DRB Application No.: 05DRB-00712 (SBP)
Project Name: JOURNAL CENTER LOT 10A
Agent: John Klee

DRB Application No.: 05DRB-00711 (SBP)
Project Name: JOURNAL CENTER LOT 10B
Agent: John Kell

**CITY OF ALBUQUERQUE
PLANNING DEPARTMENT
May 11, 2005
DRB Comments**

RE: Lots 10A & 10B, Journal Center/SPBPs

SHEET TITLE: LANDSCAPE PLAN
 DRAWN BY: JC

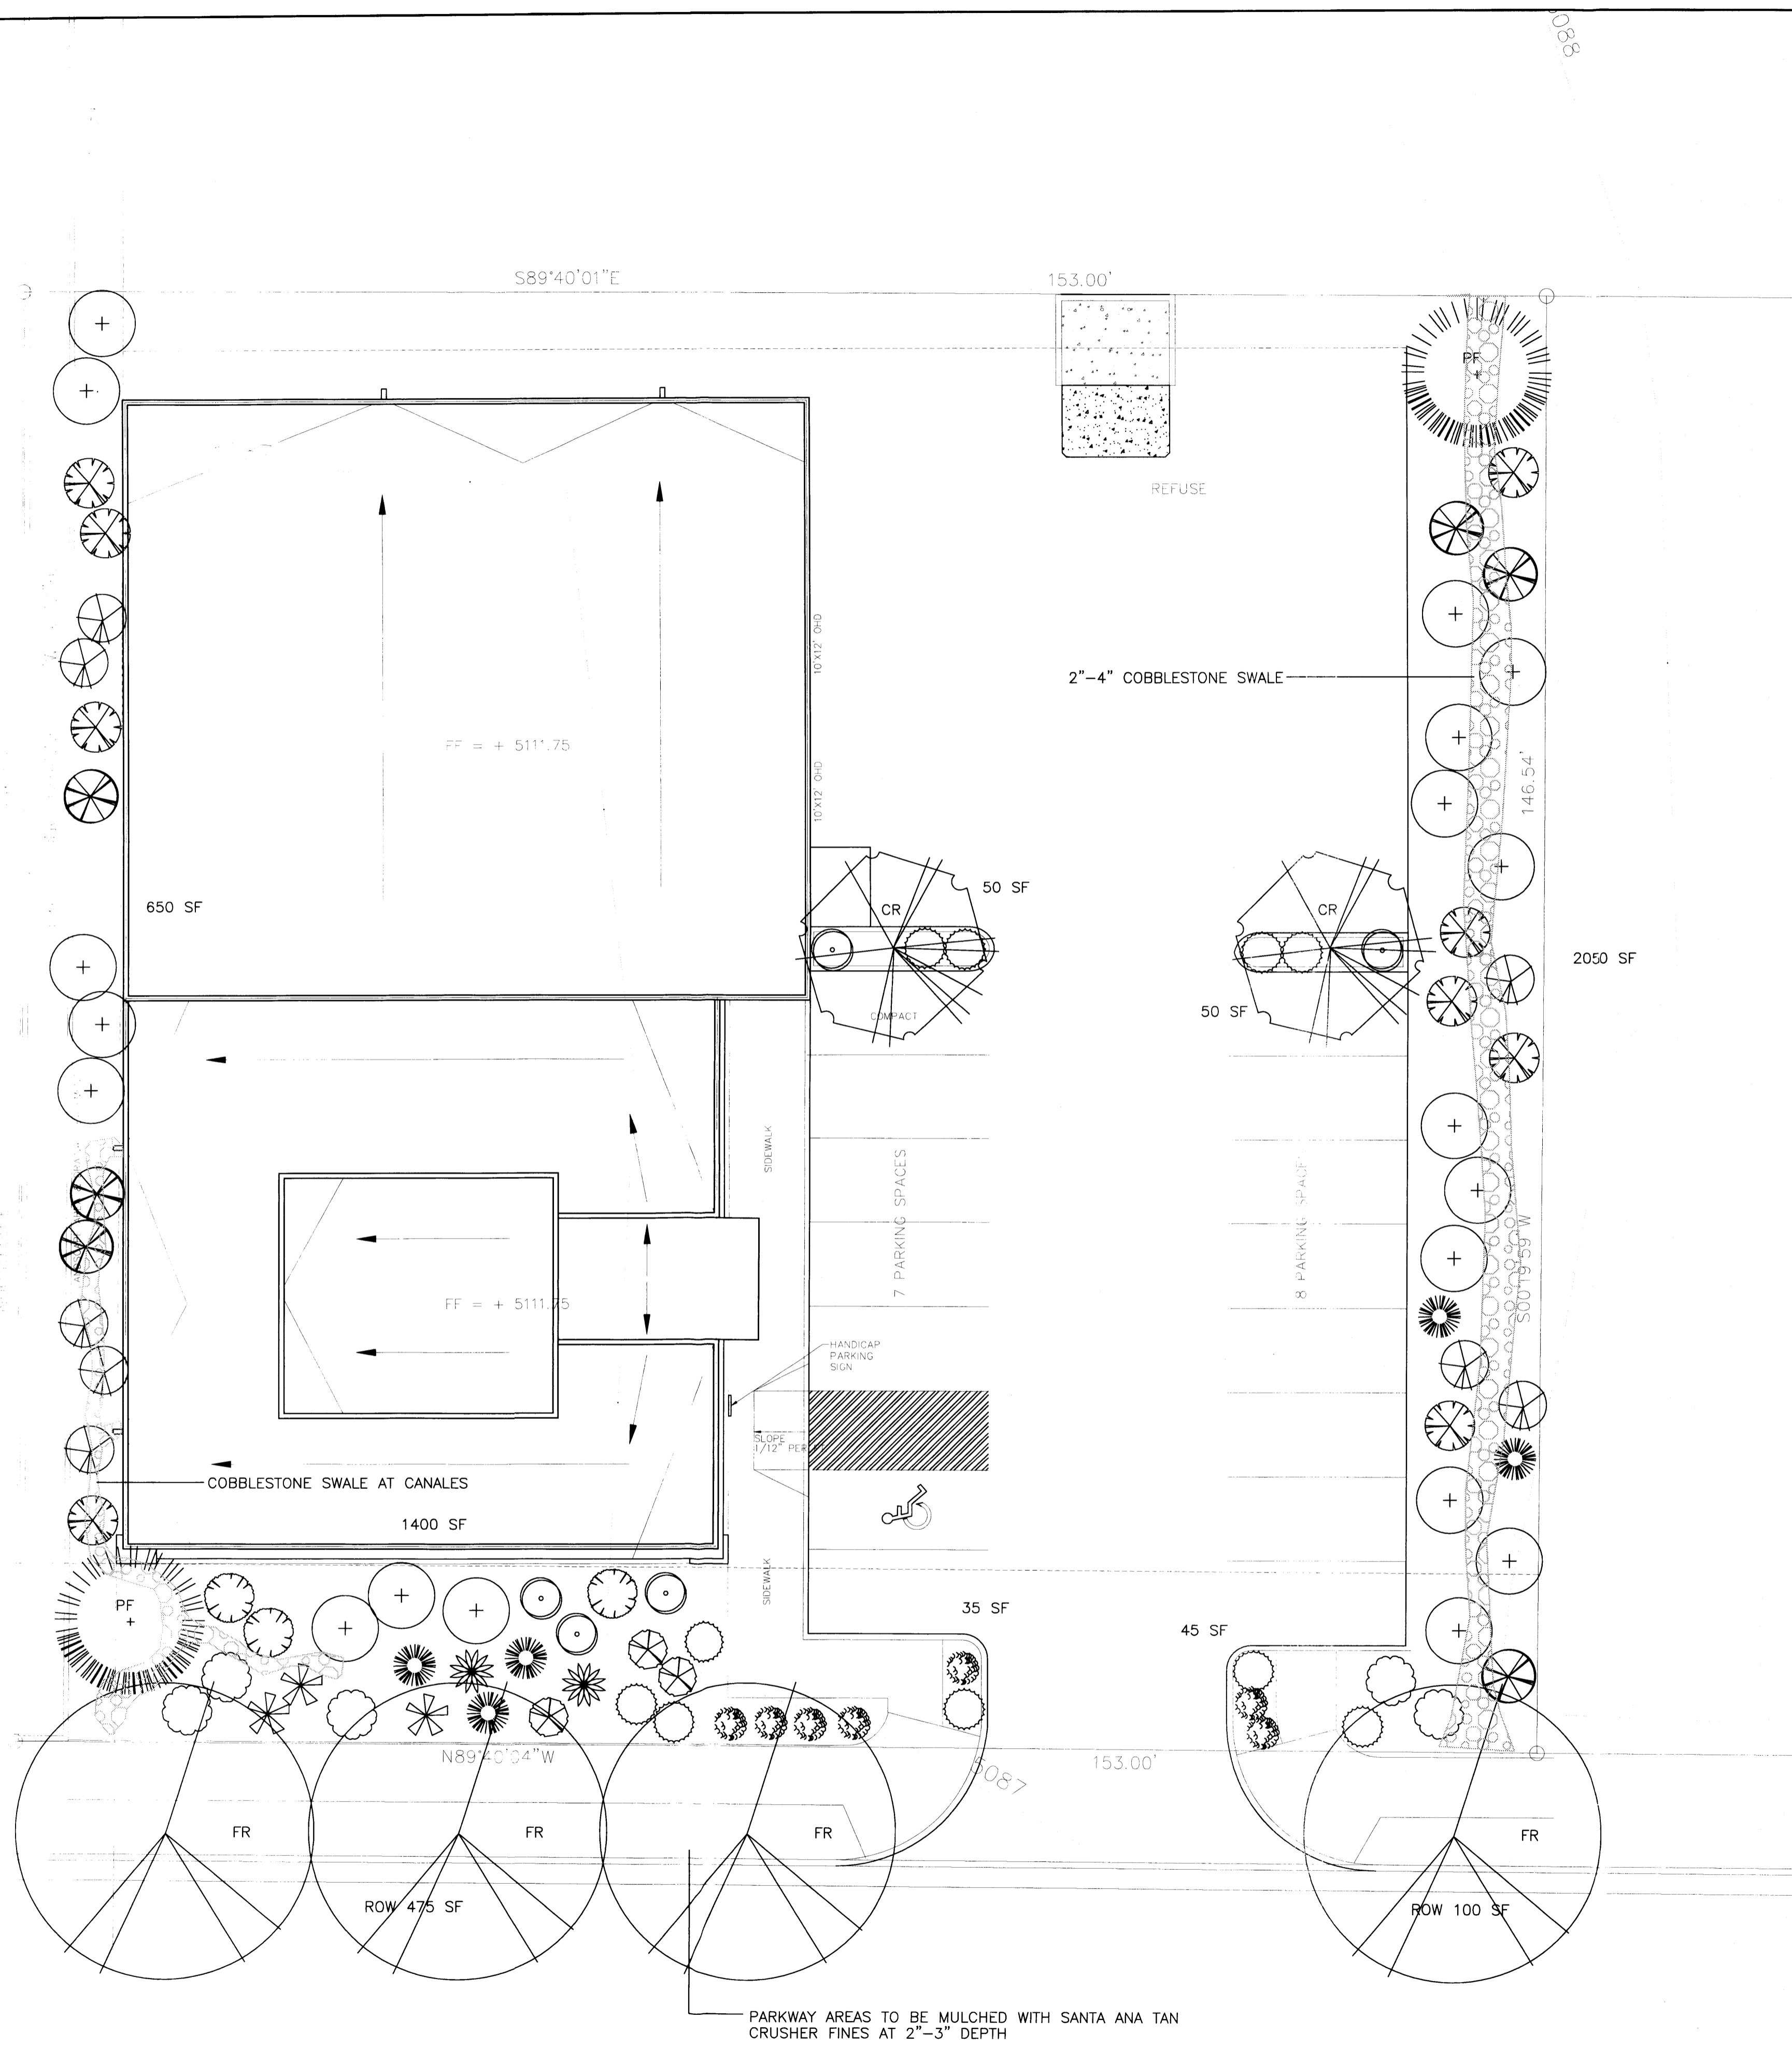
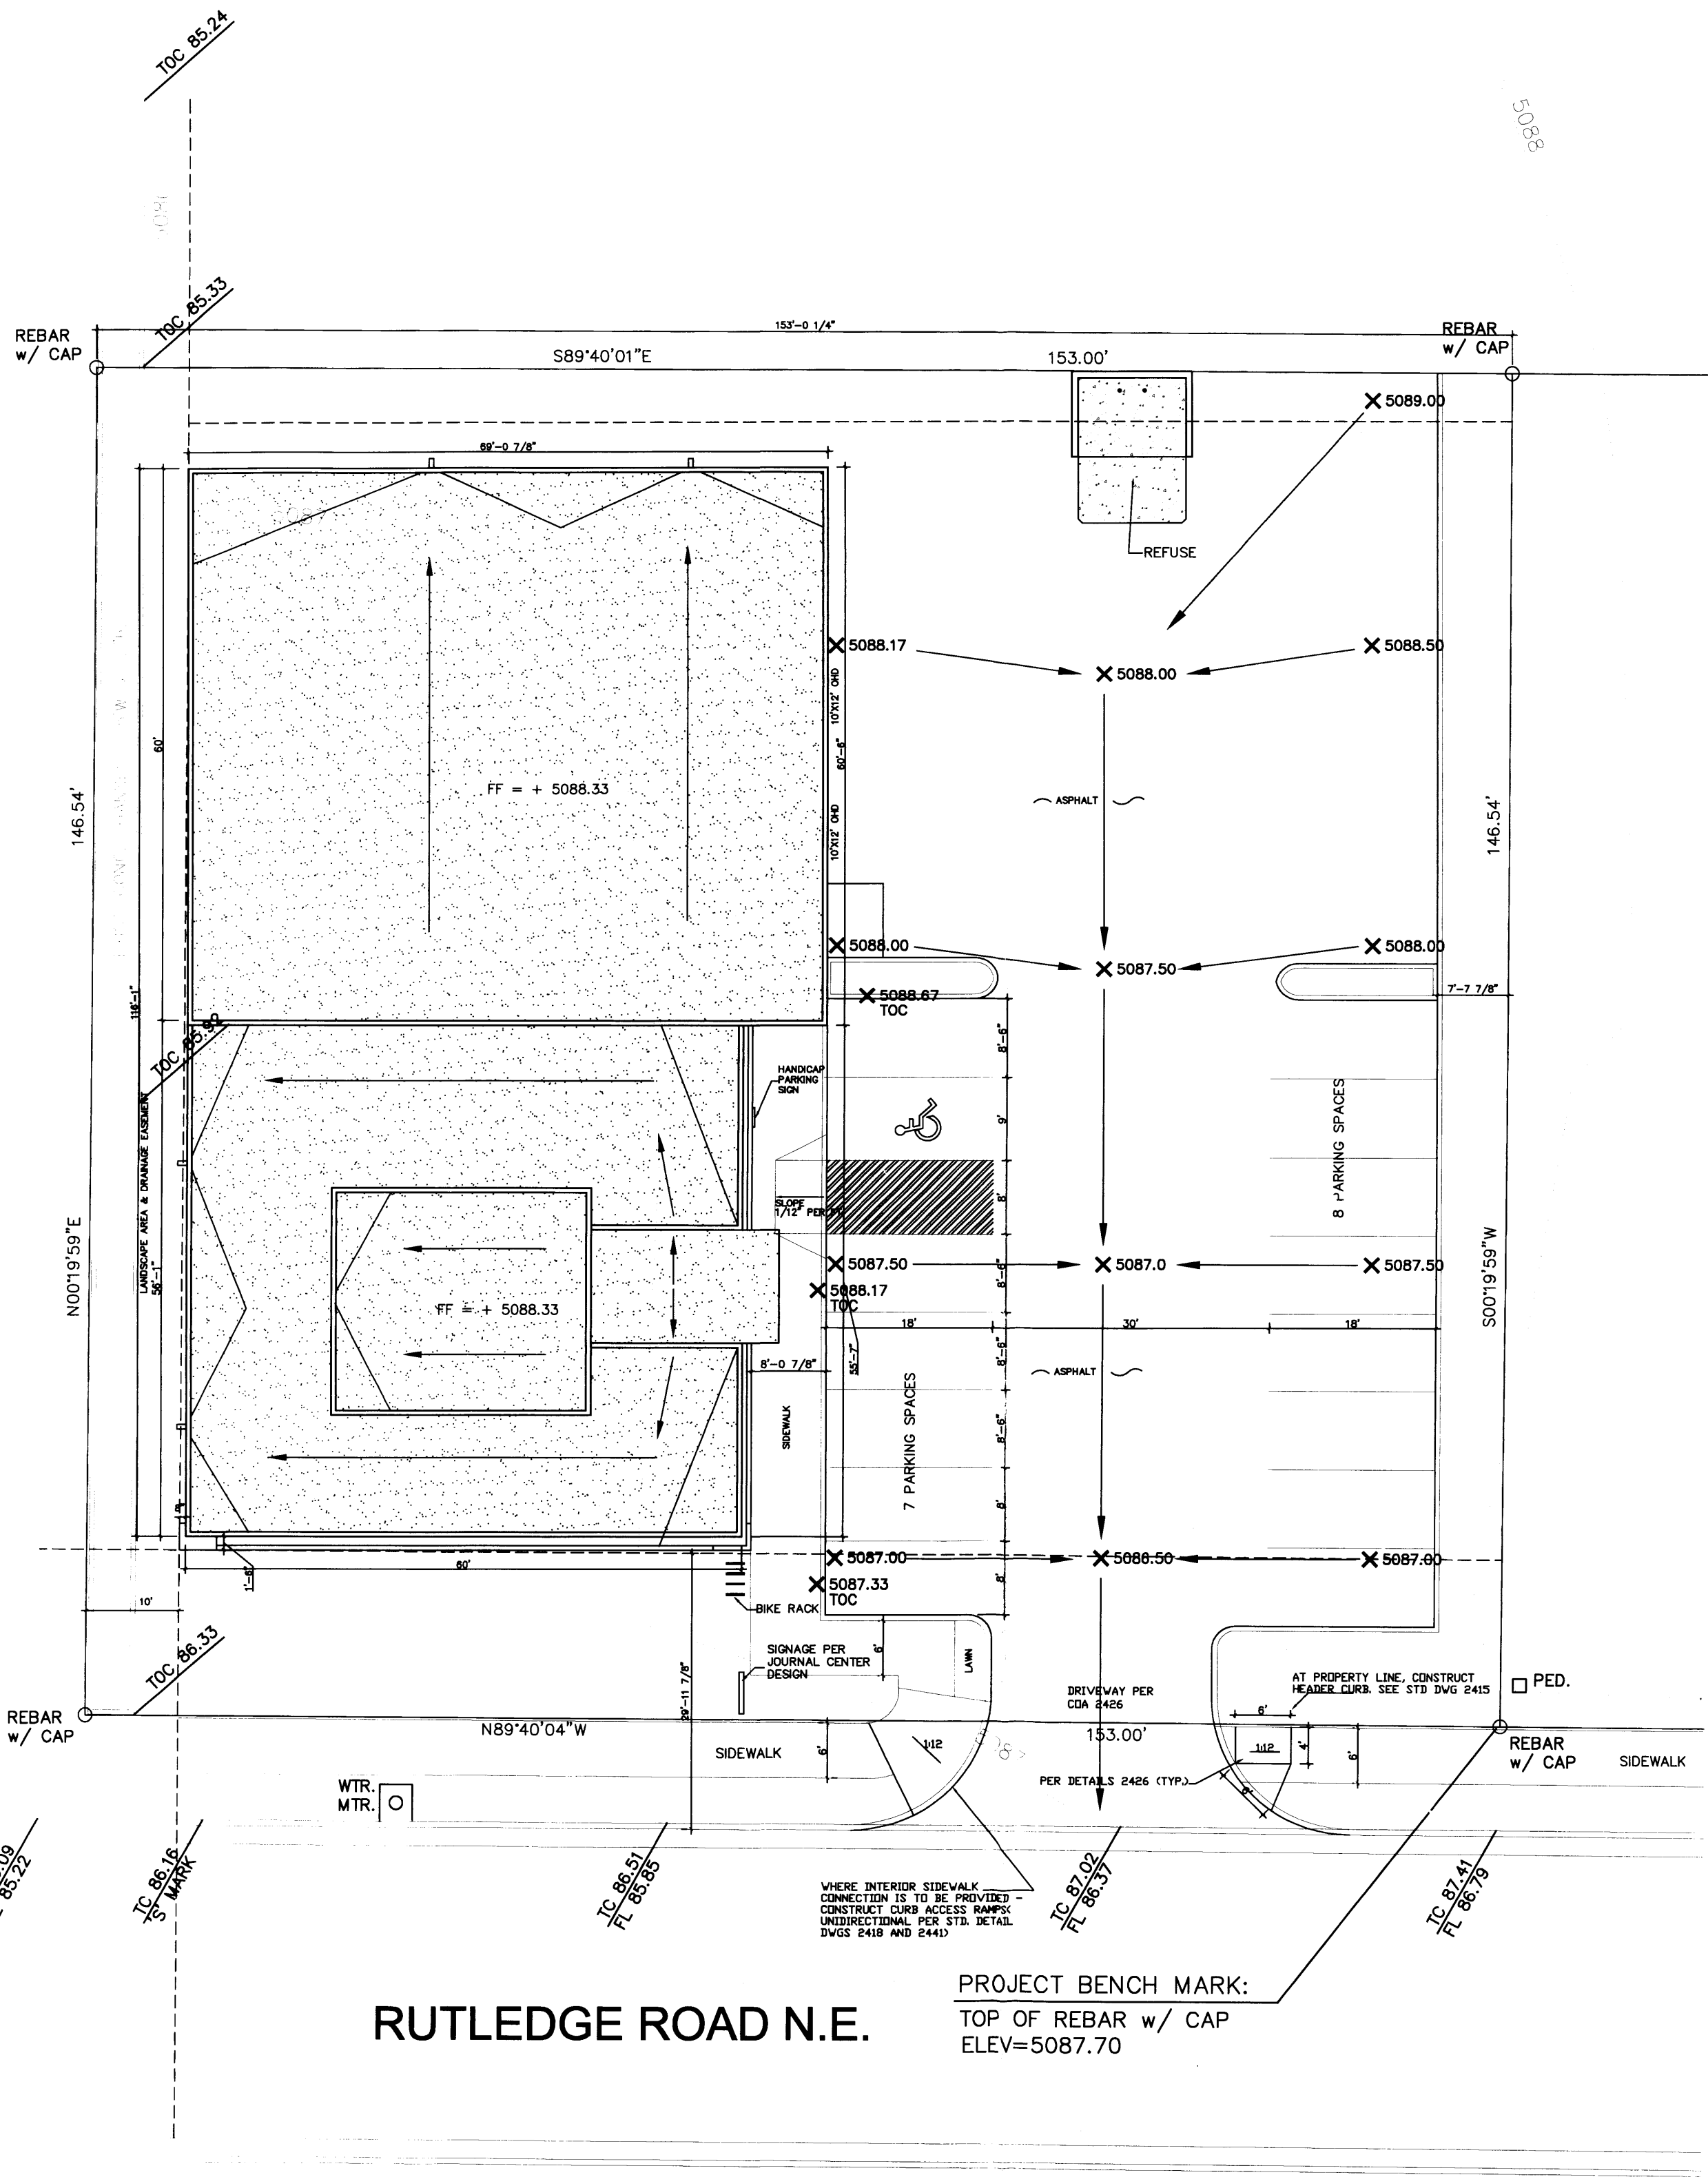
1. The Journal Center ARC approval letters are needed for Planning approval.
2. The property lines are not clearly indicated on the Landscape Plans as required.
3. All of the existing easements are not show on the site plans. For example, the 10' PUE on the plat is missing from both site plans.
- ✓4. Several items on the checklist are neither checked nor marked with an "n/a" and explanation as to why they are "n/a".
5. Easements are missing on the Landscape Plans as well.
6. Location arrows indicating which landscaped area the square footage is for are needed.
7. Overall building width dimensions are missing on the Elevations sheets.
